**Re: Adams Street Studios, 308-312 Adams Street,  
(K-17/D101)  
Approval of Permanent Certificate of Occupancy,  
Engineer's Stamp Dated: 09-23-08  
Engineer's Certification Date: 4-29-09**

**Re: Adams Street Studios, 308-312 Adams Street,  
Reject of Certificate of Occupancy - Not Approved  
Engineer's Stamp dated 09/23/08 (K-17/D101)  
Certification dated 04-29-09**

Grading & Drainage Plan

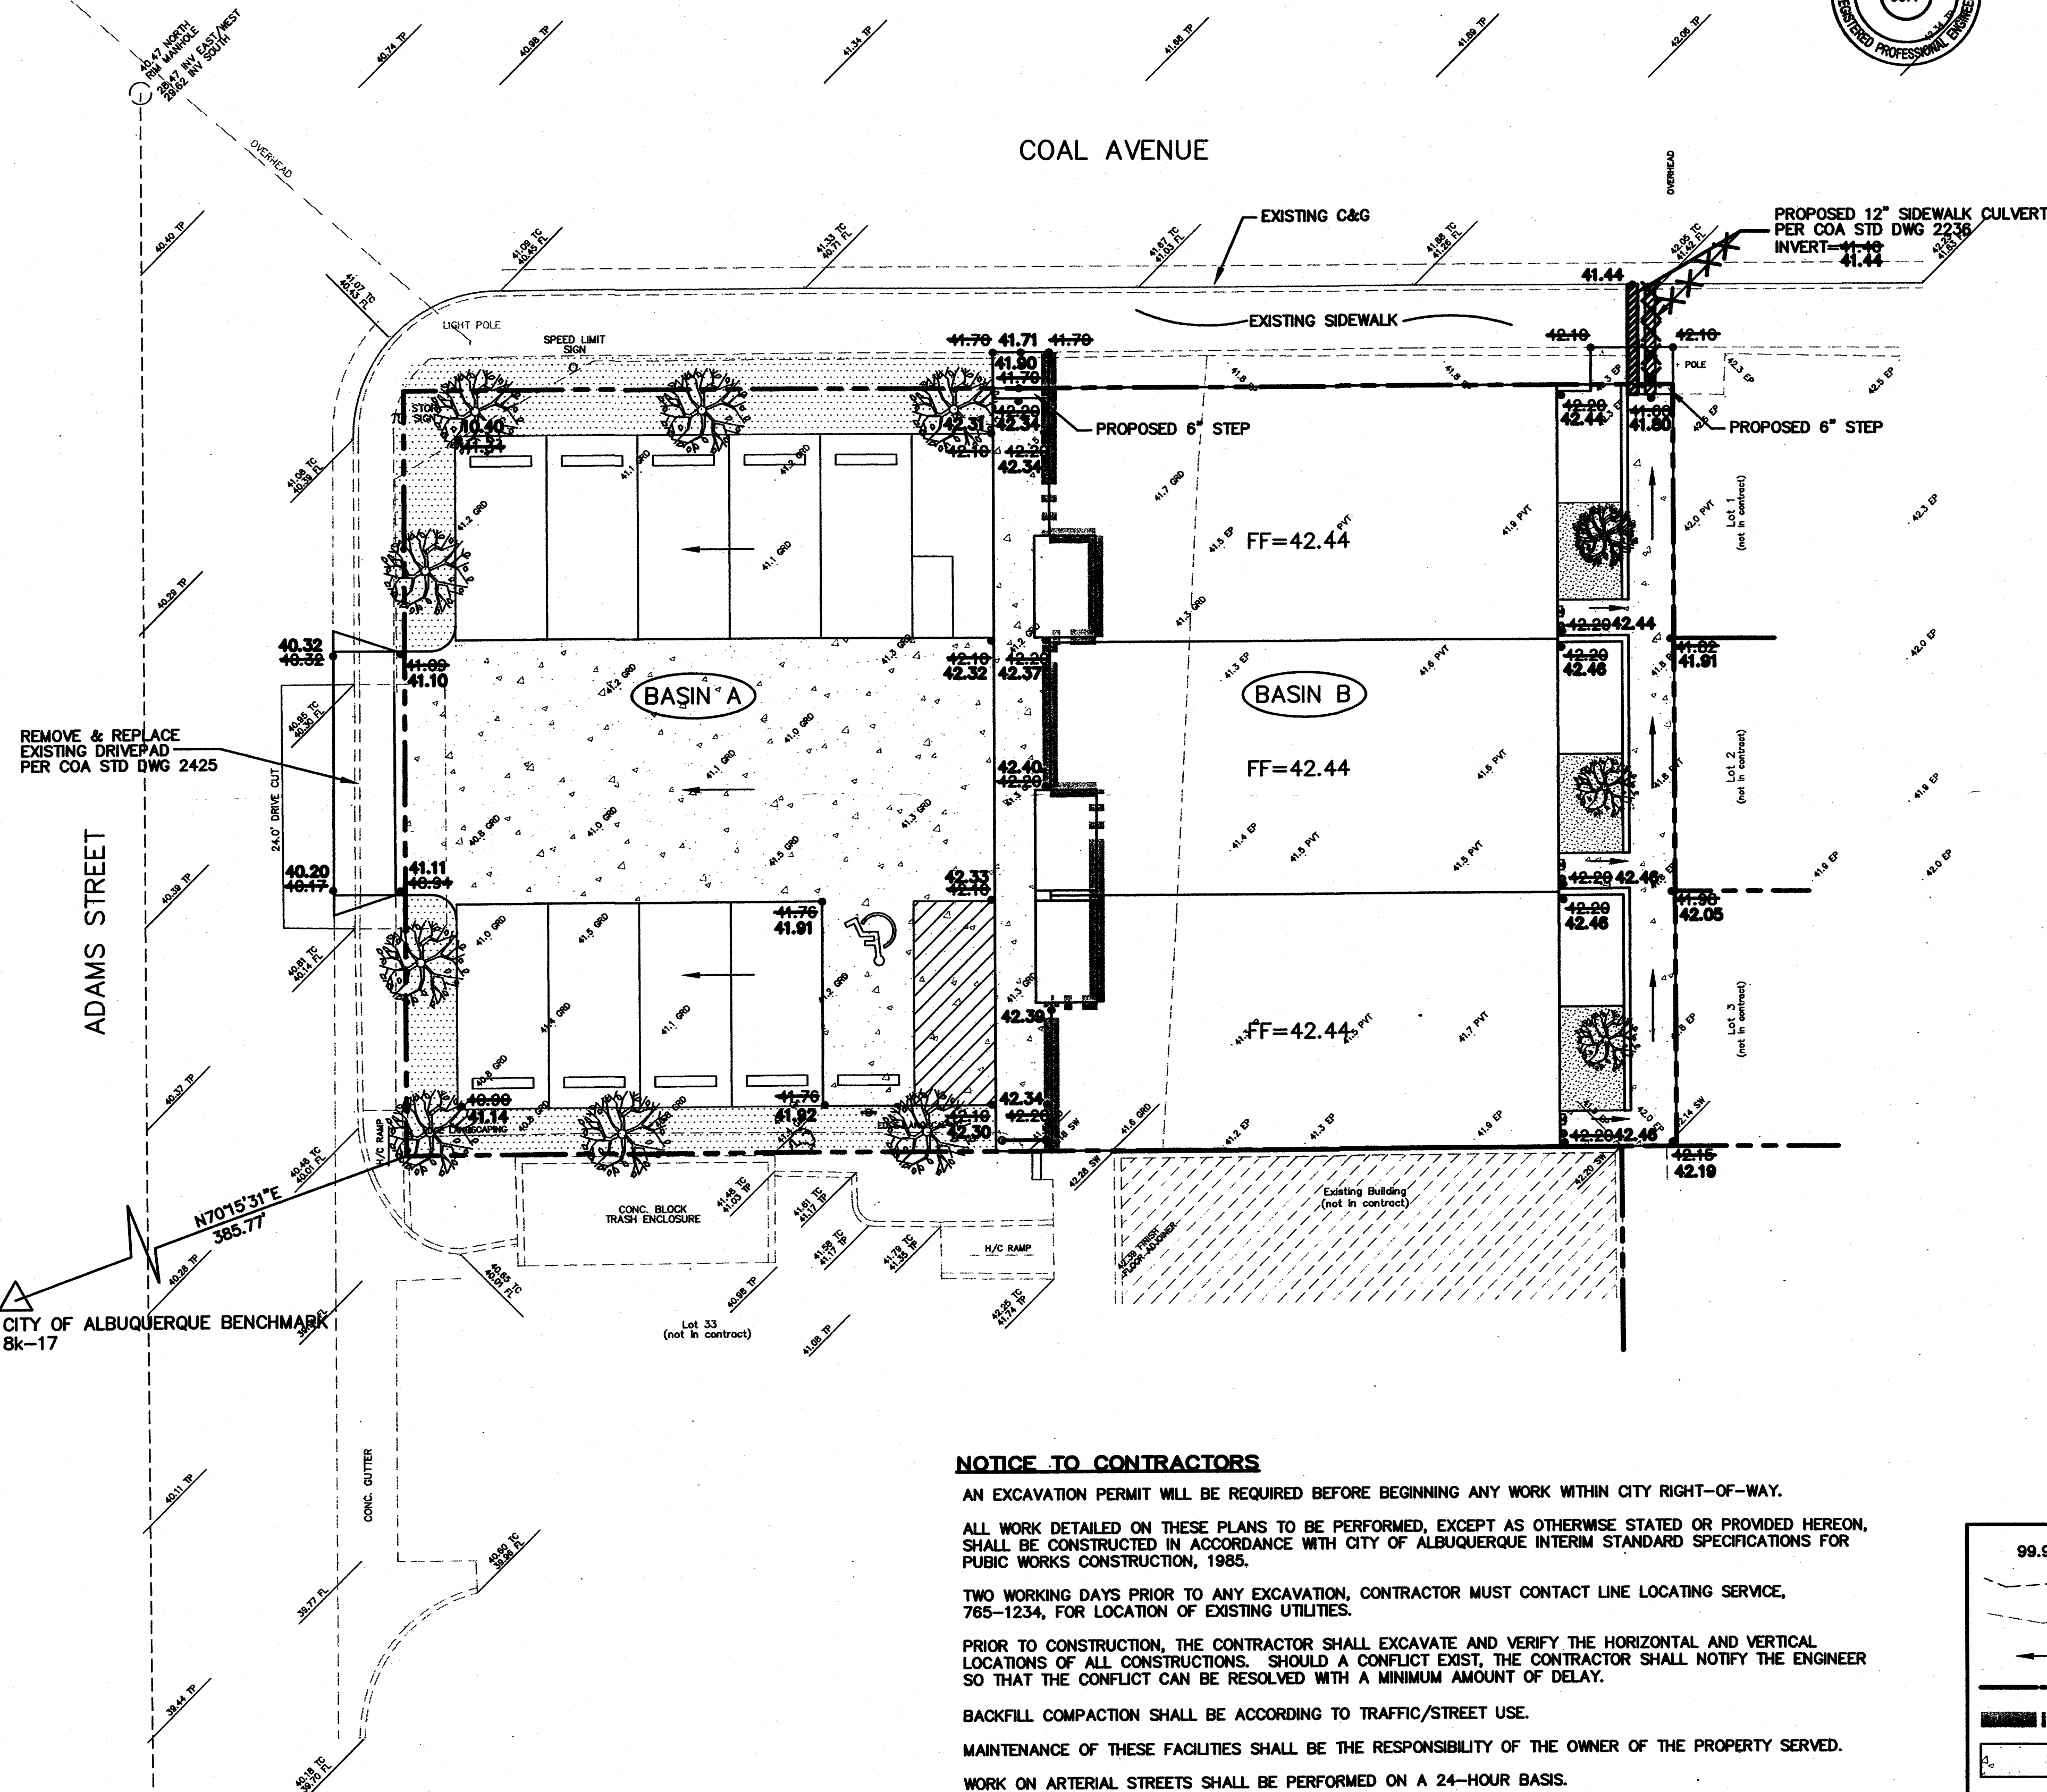
Based upon the information provided in the Certification received 4-29-09 the above referenced Certification is not approved for Permanent Certificate of Occupancy.

The sidewalk culvert will need Duane Schmitz's approval prior to any permanent or temporary Certificate of Occupancy approval.

Based upon the information provided on 4/29/09, the above referenced certification is approved for release of Permanent Certificate of Occupancy by Hydrology.
